LAND OFF CAMP ROAD, UPPER HEYFORD

FLOOD RISK ASSESSMENT AND DRAINAGE STRATEGY ADDENDUM 1

Project Name	: Land off Camp Road, Upper Heyford
Job No	: 22-192
Note Title	: Flood Risk Assessment and Drainage Strategy Addendum 1
Author	: HM
Checked	: GG
Approved	: GG
Date	: September 2023

1.1.2 The proposed drainage strategy was submitted to Cherwell District Council in October 2022 as part of planning application 22/03063/F.

Proposed External Levels

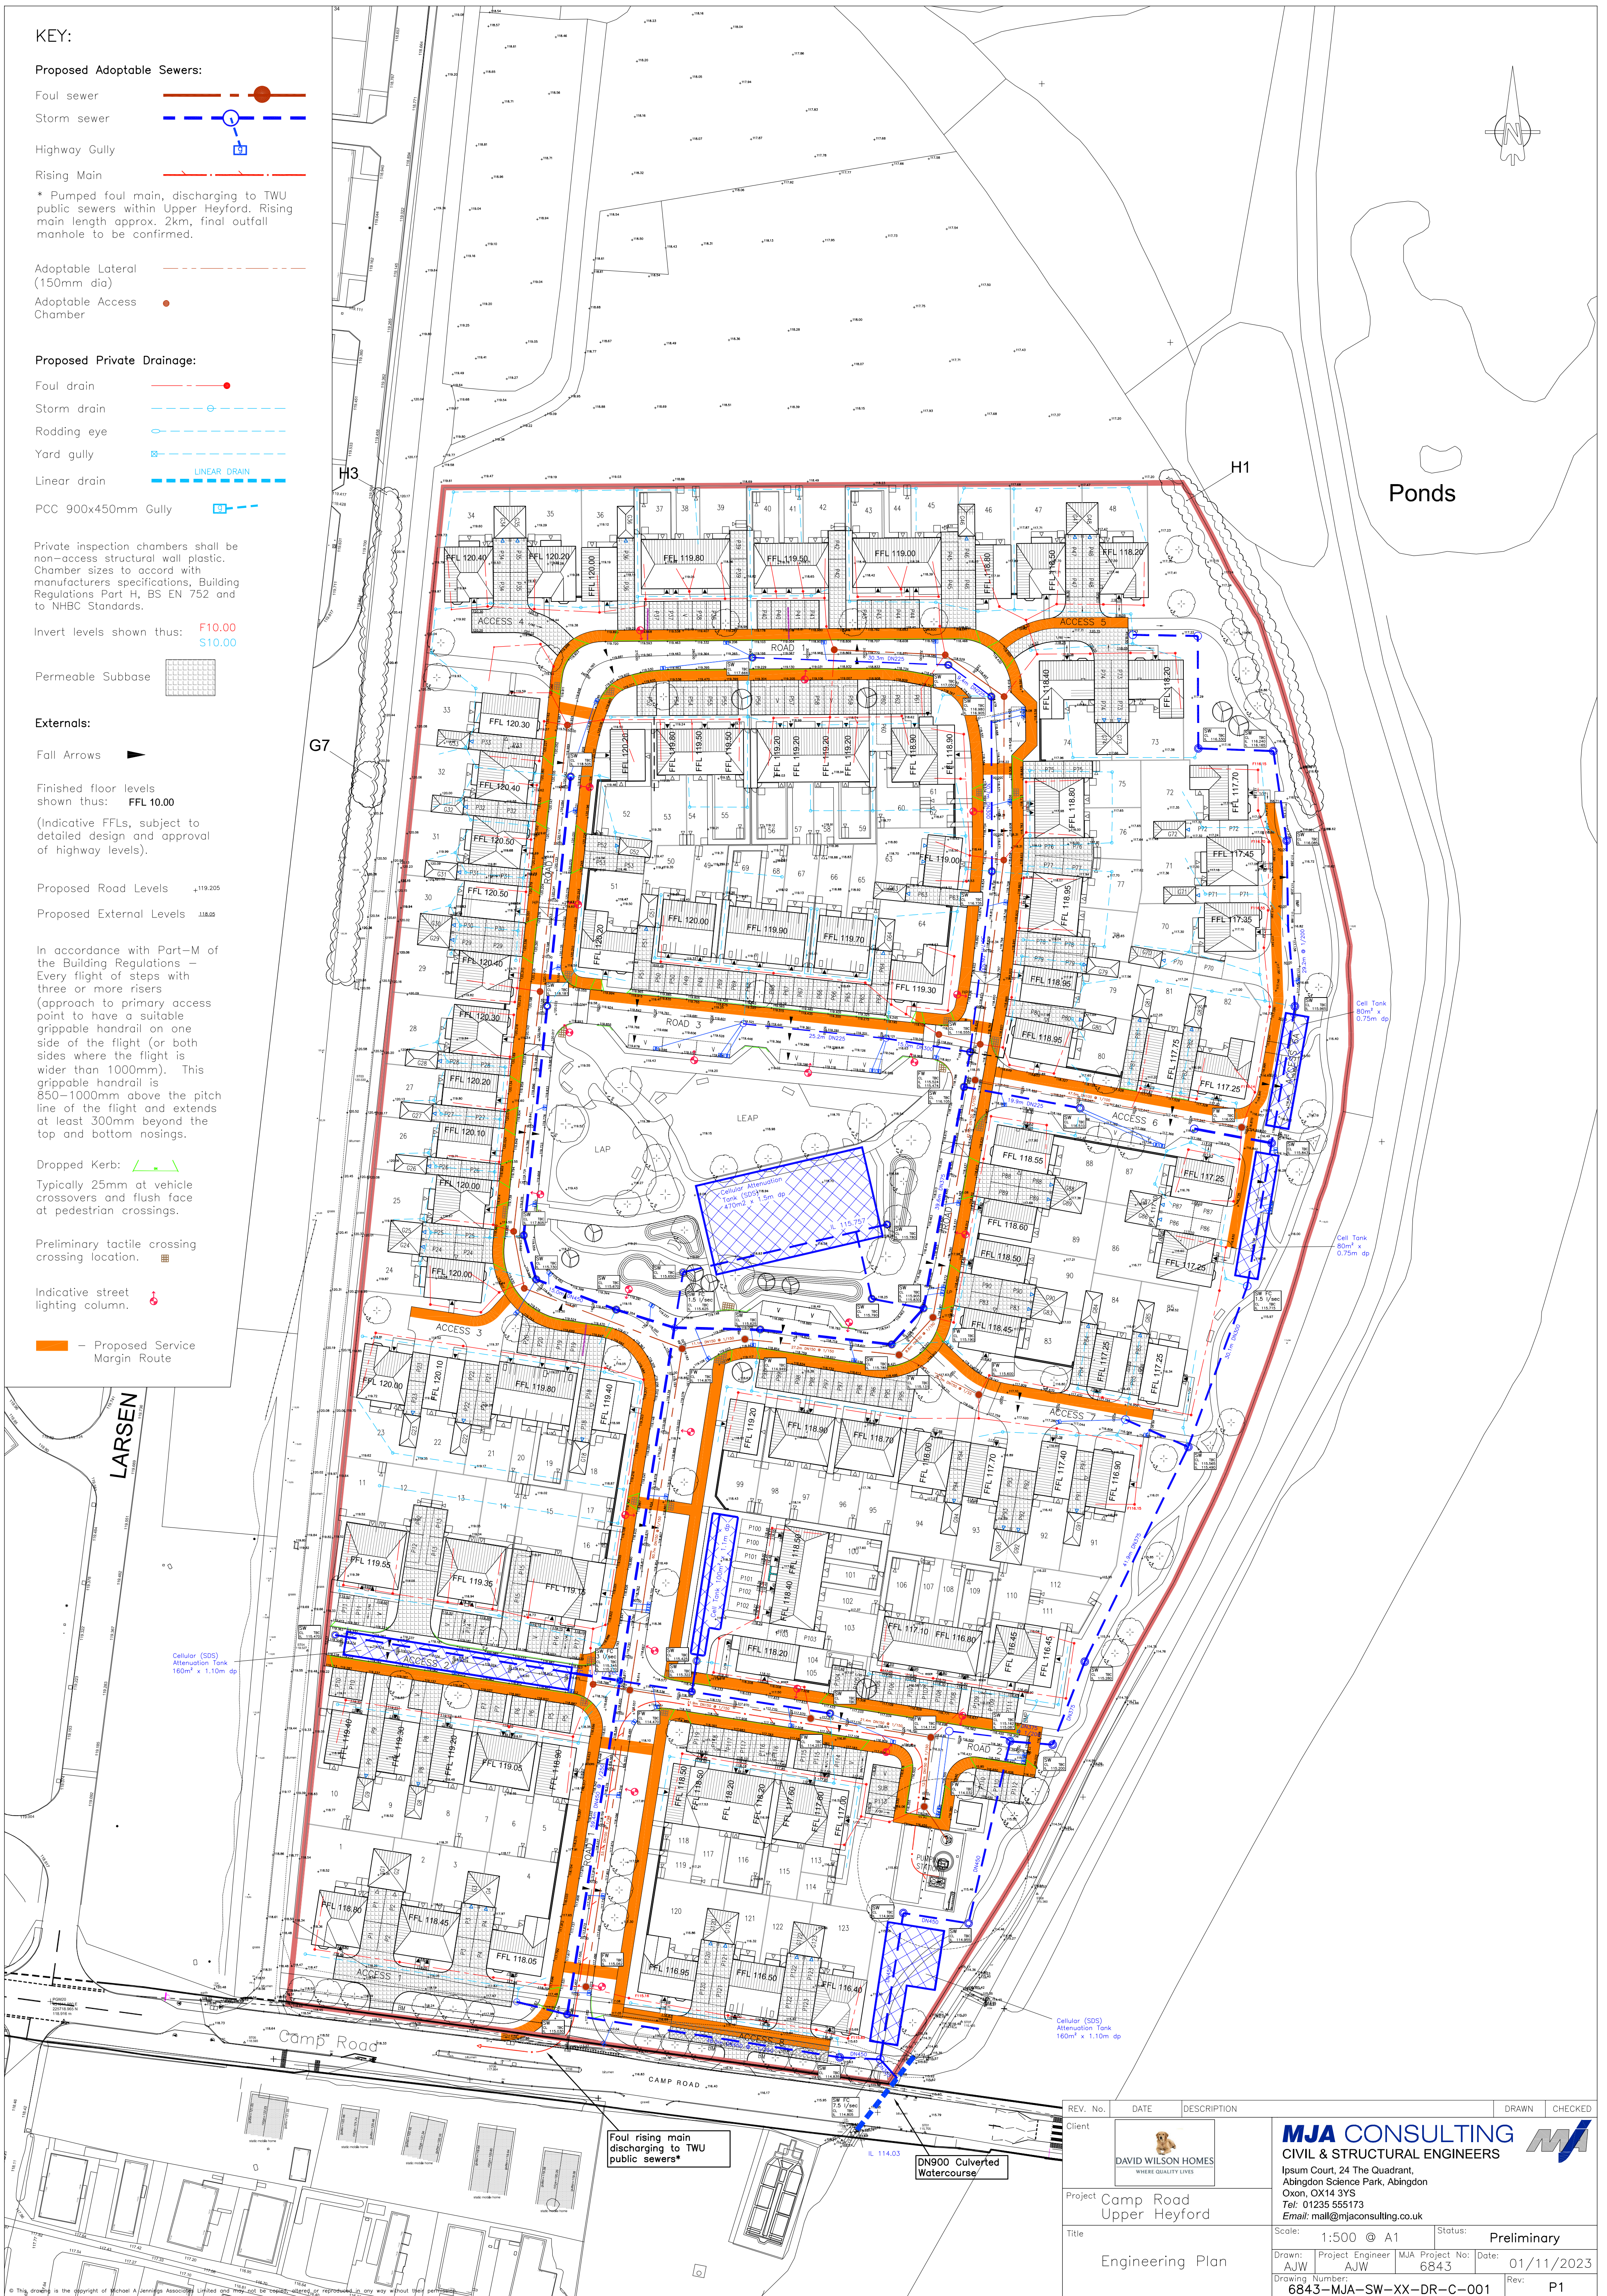
"Provide surface water flood exceedance plan, demonstrating with flood arrows and proposed levels that all surface water will be kept away from structures and within the site boundary."

2.1.9 The exceedance flow route drawing indicates surface water would be routed within the proposed highways, and away from the new dwellings. The exceedance flow route drawing is presented in **Appendix E**. The finished floor levels (FFLs) of dwellings would be a minimum of 150 millimetres (mm) above the surrounding ground levels.

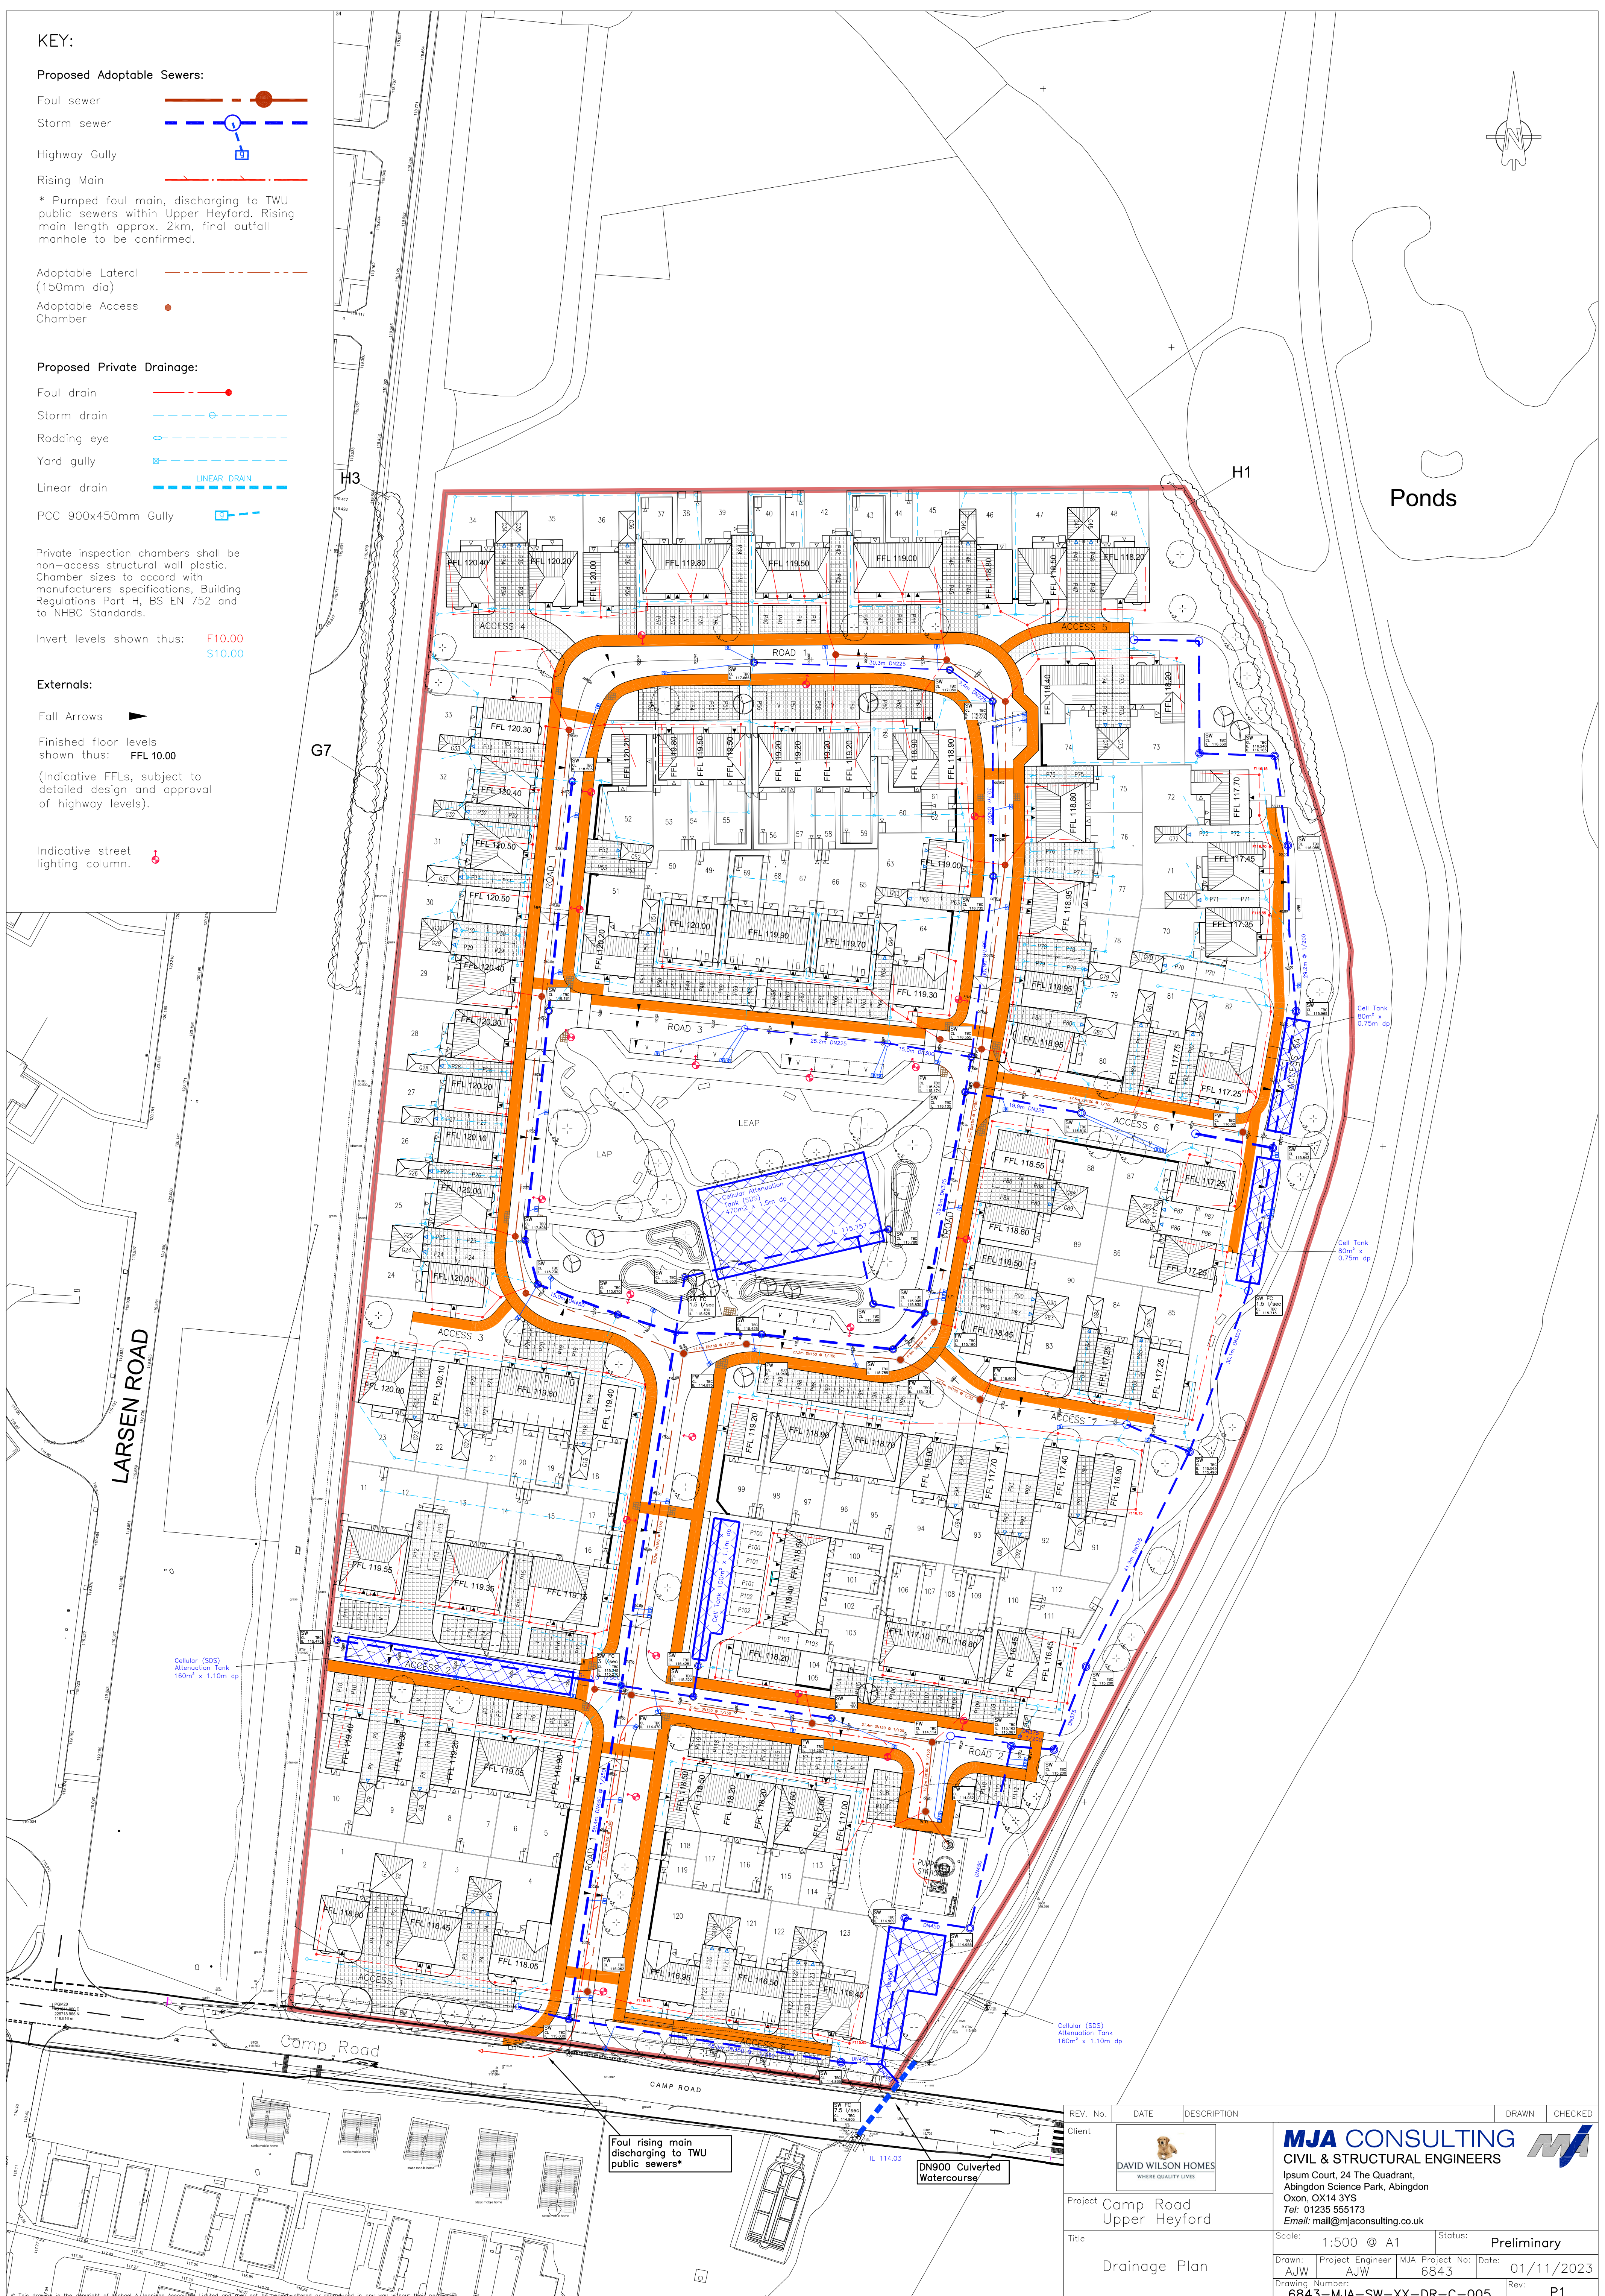
"As part of a full application drawings are expected to be detailed. Provide invert and cover levels of all SuDS/drainage infrastructure. Include pipe gradients and pipe numbering which should read in line with the calculations."

2.1.2 The detailed drainage strategy drawing along with the preliminary site levels strategy are presented in **Appendix B**, alongside the associated detailed network calculations.
